# Cottam Solar Project

## Written Summary of the Applicant's Oral Submissions & Responses at Issue Specific Hearing 1 (Draft DCO) and Responses to Action Points

Document Reference: EX1/C8.1.5

### **Issue Specific Hearing 1 (Draft DCO) Written Summary of the Applicant's Oral Submissions and responses to Action Points**

Hedgerows to be removed and  
Tree Preservation Orders (TPO) - Index Plan

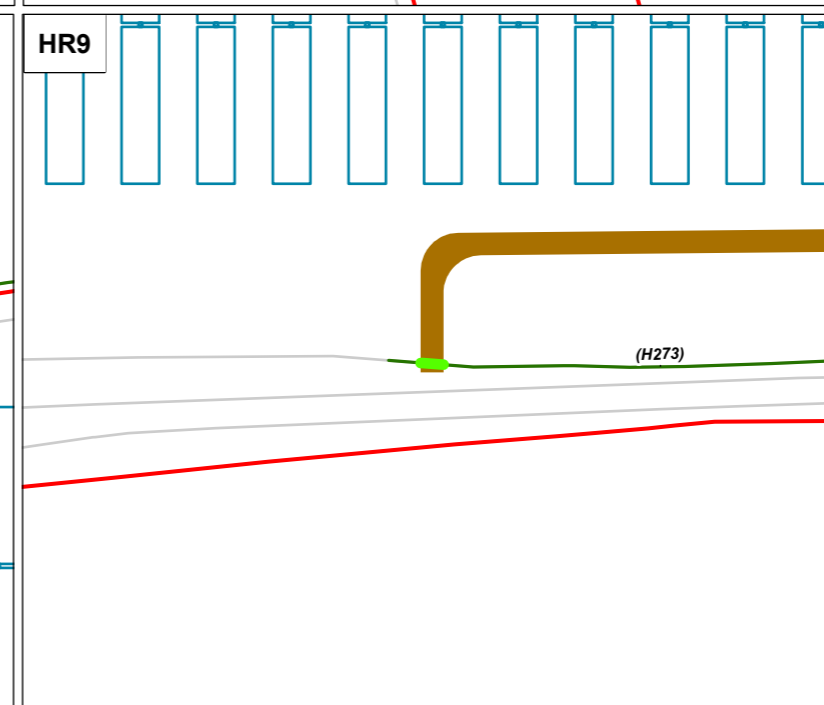
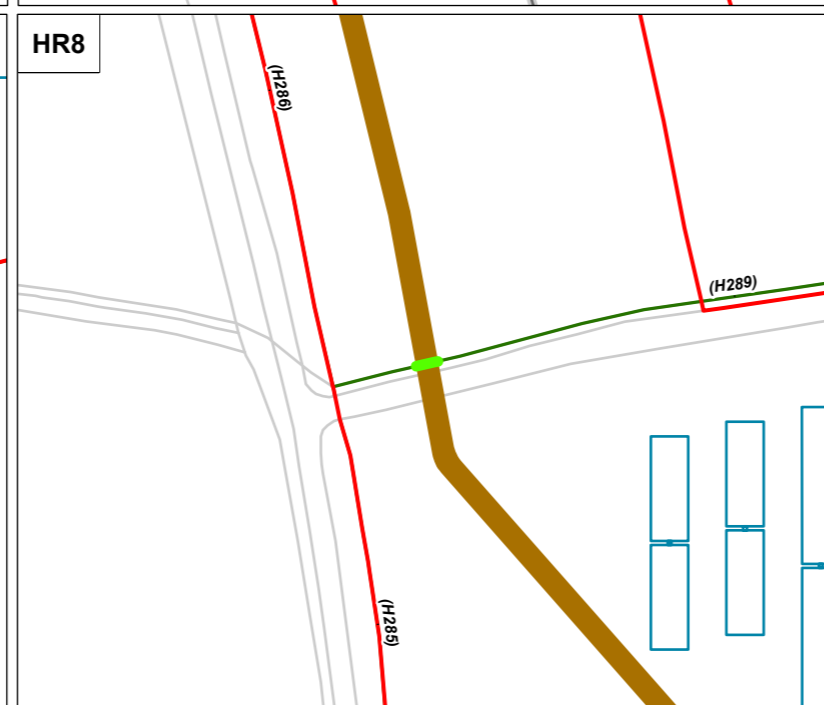
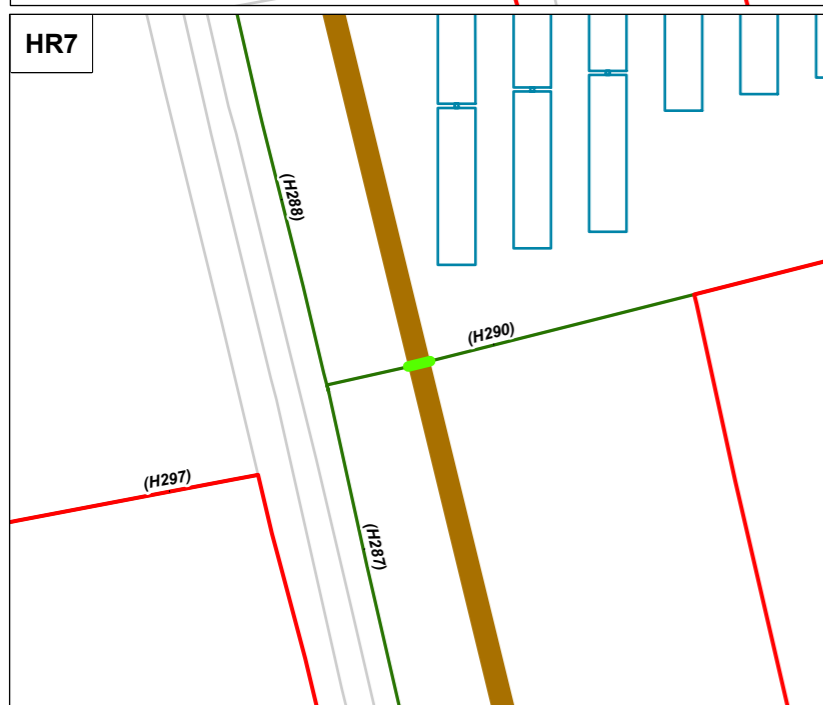
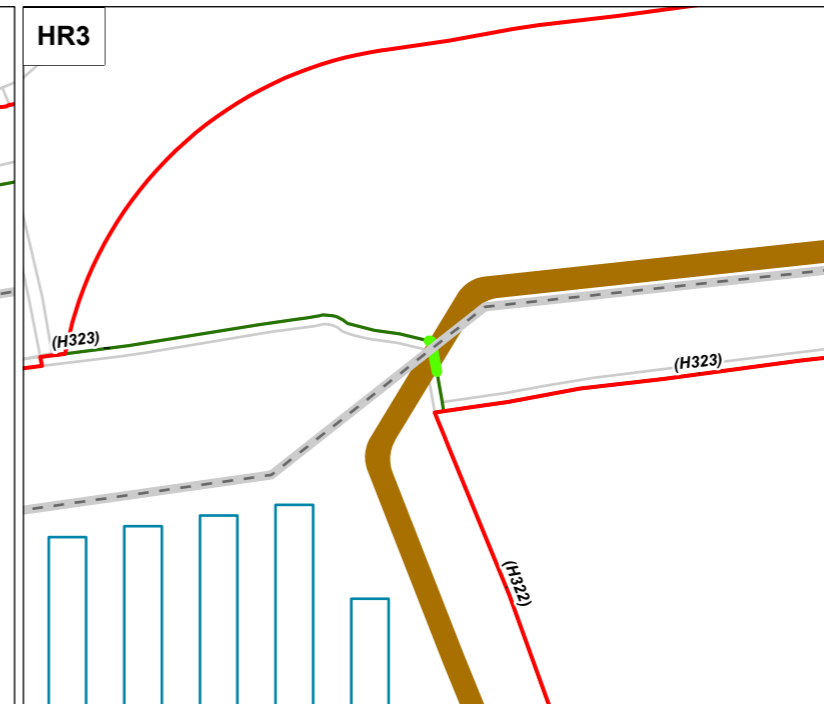
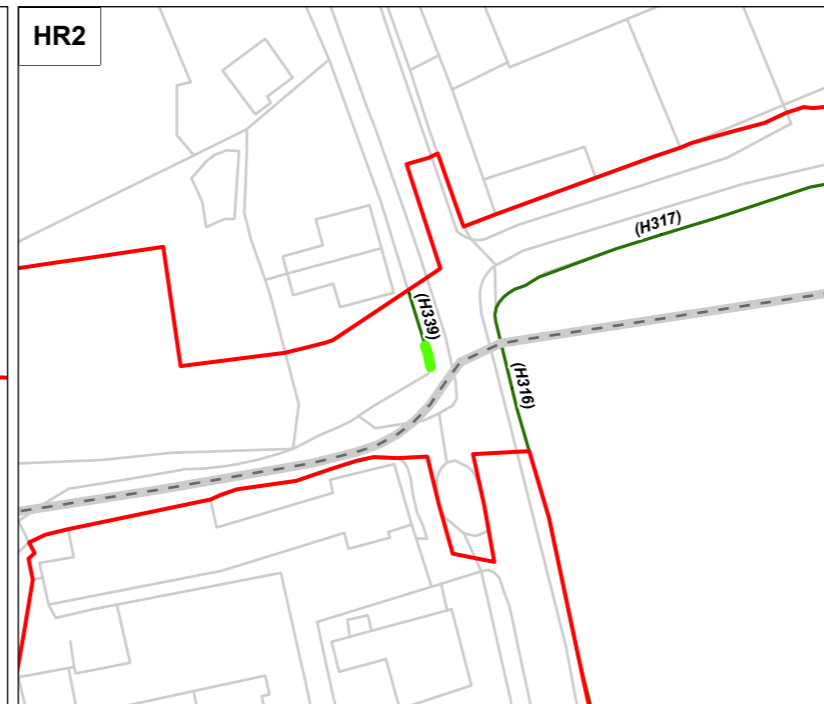
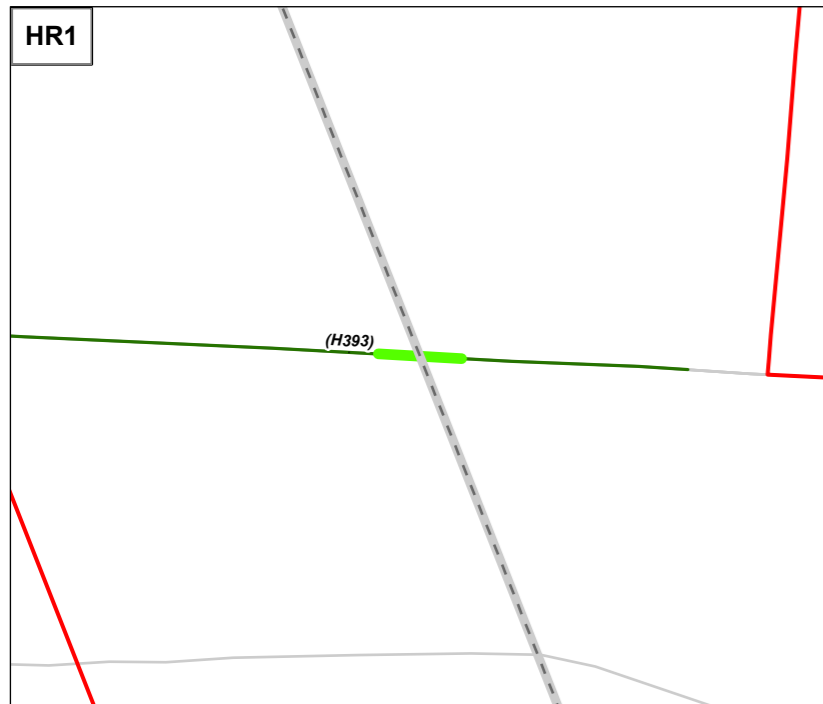
5s	<p>The ExA invited those present to comment on this Agenda Item relating to Article 38.</p> <p>Lincolnshire County Council queried the number of trees and hedgerows to be removed and the impact of this on the LVIA.</p> <p>Further questions were raised by Sturton by Stow Parish Council, 7000 Acres and Mr Skelton in relation to the removal of hedgerows.</p>	<p>Ms Brodrick stated that, as briefly touched on in Open Floor Hearing 1, the powers set out in Articles 38 and 39 are deliberately broad as the detailed design is not known at this stage. For instance, the grid connection cables will be micro-sited within the grid connection corridor. Whilst the Applicant has applied for the power to remove any part of the hedgerows within the Order Limits and listed in Schedule 13, this is power is controlled and limited by the management plans secured by the Requirements. Ms Brodrick emphasised that the Important Hedgerow Plan [APP-013] needs to be read in the context of the Requirements and the assumptions set out in the Environmental Statement, which will be taken into account when the relevant planning authority approves the final Landscape and Ecological Management Plan pursuant to Requirement 7.</p> <p>Ms Brodrick further explained that further detail regarding the removal of hedgerows is set out in the outline Landscape and Ecological Management Plan [APP-339]. Ms Brodrick also referred to Chapter 9 - Ecology and Biodiversity of the Environmental Statement [APP-044] which sets out the anticipated extent of hedgerow removal for the solar PV sites and grid connection. Whilst the Applicant has sought a wide ranging power to enable flexibility for the detailed design, the actual amount of hedgerows removed for the Scheme will be significantly less than the lengths shown in Schedule 13.</p>

#	ExA Question / Item for discussion	Applicant's response
		<p>The Applicant agreed to consider whether the drafting could be amended to provide more clarity as to the extent of hedgerow removal. The Applicant also agreed to look at specific hedgerows mentioned by Interested Parties in more detail to provide additional information as to why such hedgerows had been included (for example, removal of hedgerows for enable access for abnormal loads during construction). In particular, the Applicant agreed to provide details of the works required to hedge numbered 275 in response to comments made by Sturton by Stow Parish Council.</p> <p>In response to comments made on behalf of 7000 Acres, Ms Brodrick confirmed that the word, "substantially" is used in Requirement 7(2) when referring to the final plans being in substantially in accordance with the outline plans to ensure that the most appropriate and up to date approaches and technology available at the time of preparation of the final plan can be used. The final plan will be more detailed and restrictive on the undertaker (as the detailed design will be known) and this approach is typical for DCOs and of benefit to stakeholders. She reiterated that the requirements in the dDCO limit the amount of hedgerow the undertaker can remove, and this has to be approved and be in accordance with the impacts assessed in the Environmental Statement.</p> <p>Ms Brodrick stated that the worst case assessed in the Environmental Statement did not include the removal of all hedgerows, as this was not the intention of the Scheme. Ms Brodrick reiterated that the powers had to be read in conjunction with the Requirements.</p> <p><b>Post hearing note:</b> The Applicant has considered the provisions relating to hedgerow removal in the dDCO and outline management plans. Please see the Applicant's response to Action 7 in the table below. The Applicant has responded to Sturton by Stow Parish Council's concerns regarding the intentions for hedgerow 275 and other hedgerows at Deadline 1 within <b>C8.11.10 The Applicant's Response to Procedural Deadline A and Other Submissions</b>. Specifically, the response to SSPC2-08 confirms that: "It is not anticipated that the removal of any section of hedgerows H275, H278, H279 and H280 will be required".</p>
